Re: 64 Melthorne Drive 6112/APP/2021/917

Ms Mandeep Chaggar
Planning Officer (part time)
Planning Environment and Community Services
London Borough of Hillingdon
(E-Mail) mchaggar@hillington.gov.uk

PROPOSED REAR ELEVATION
SCALE BAR 1:50 @ A1

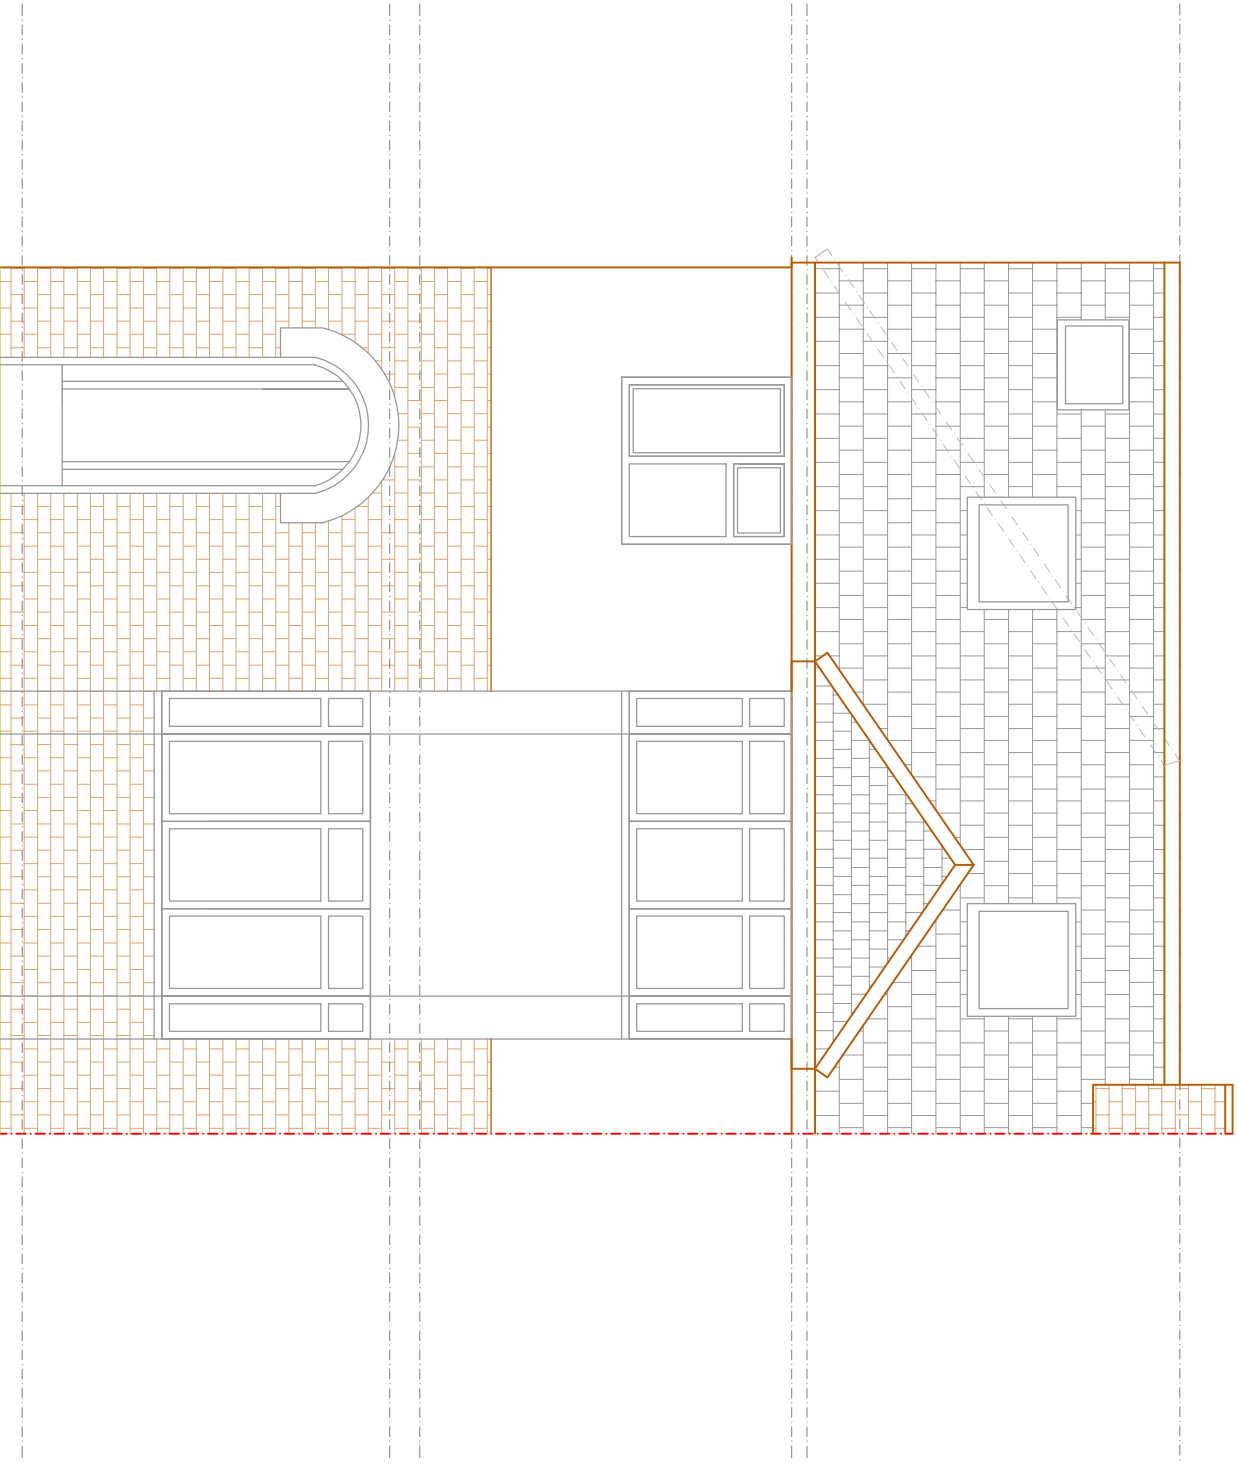
Further to my email below requesting site photos, please can you confirm the rooflights will not protrude more than 150 mm above the roof plane and lower than the highest part of the original roof.

Materials will match the existing dwelling;
The rooflights are less than 150 mm above the roof plane and lower than the highest part of the original roof.

I can confirm the roof lights will not protrude more than 150 mm above the roof plane and lower than the highest part of the original roof. I can also confirm materials will match existing.
